# Planning Services Sign Permit Review Form

Date of Submittal	Application Number	Applicant	Landowner
03/20/19	SIGN 1903-0002	Johnson Sign Co.	EIGHT RCCC 213 NC SPOUT SPRINGS LLC
Contact Person	Contact Number	Sign Location	PIN Number
Jay Johnson	517-784-3720	95 Centennial Pkwy	9594-17-0790.000

NOTES:
 (1) NEW D/F
 LIGHTED MONUMENT
 SIGN

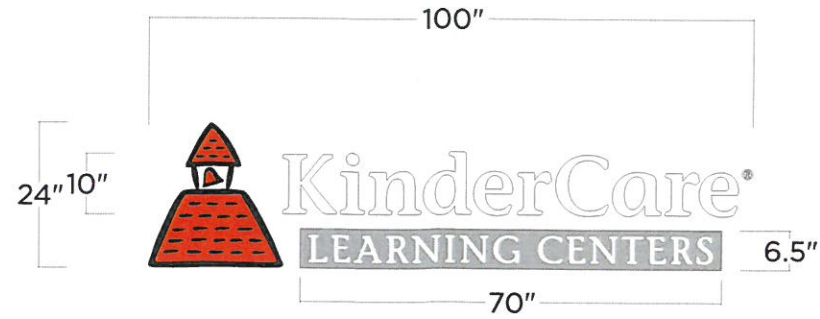
Monument: 59.75" x 74.75"  
 = 4.979' x 6.229'  
 = 31.014 sq. ft.,  
 7.02 ft tall } = OK ✓

1 FRONT (WEST) ELEVATION 3/16" = 1'-0"

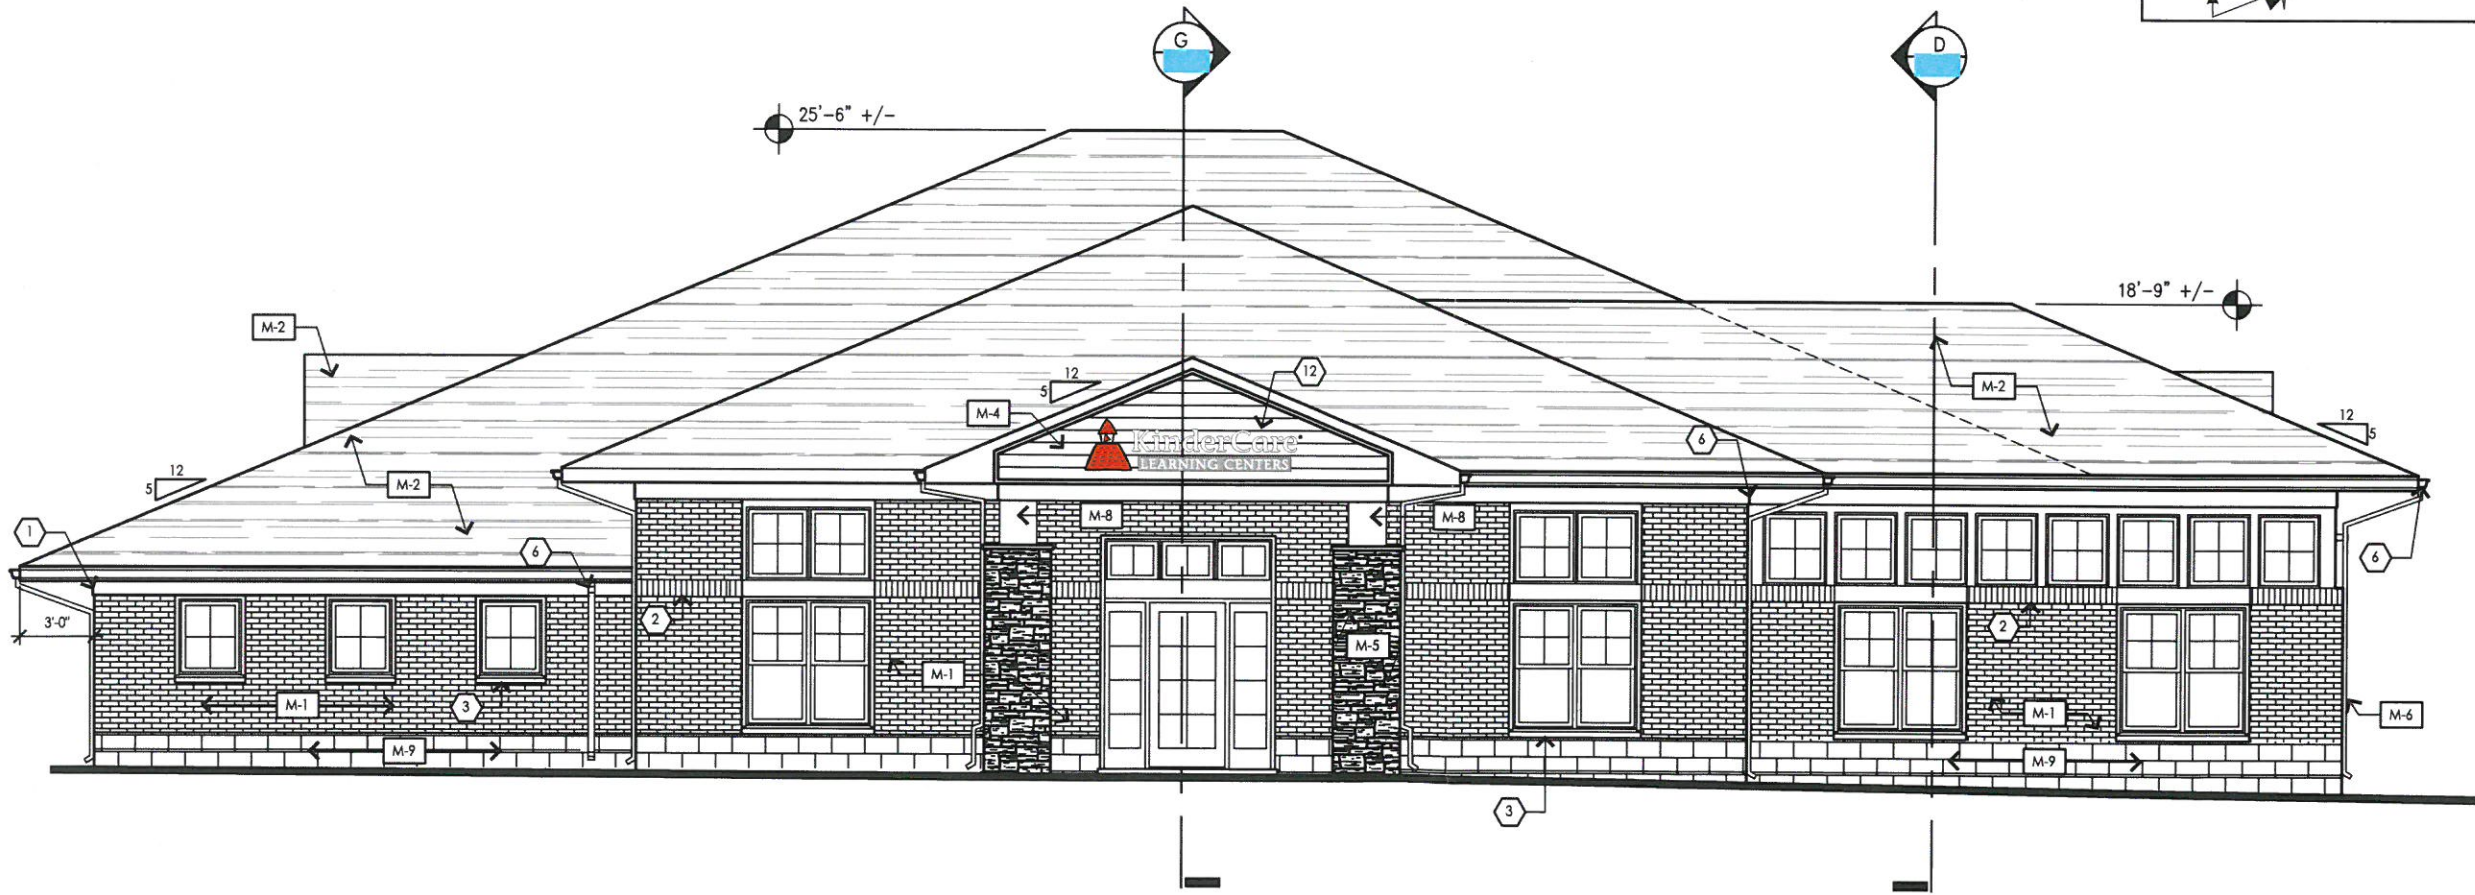
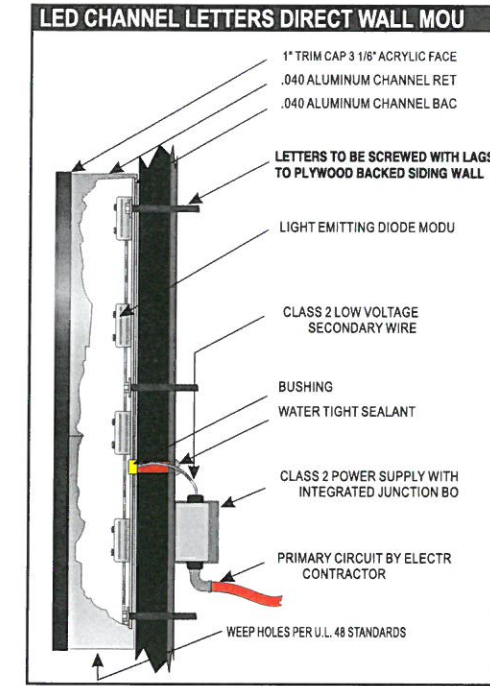
Wall Sign: 100" x 24"  
 = 8.3' x 2  
 = 16.6 sq ft = OK ✓
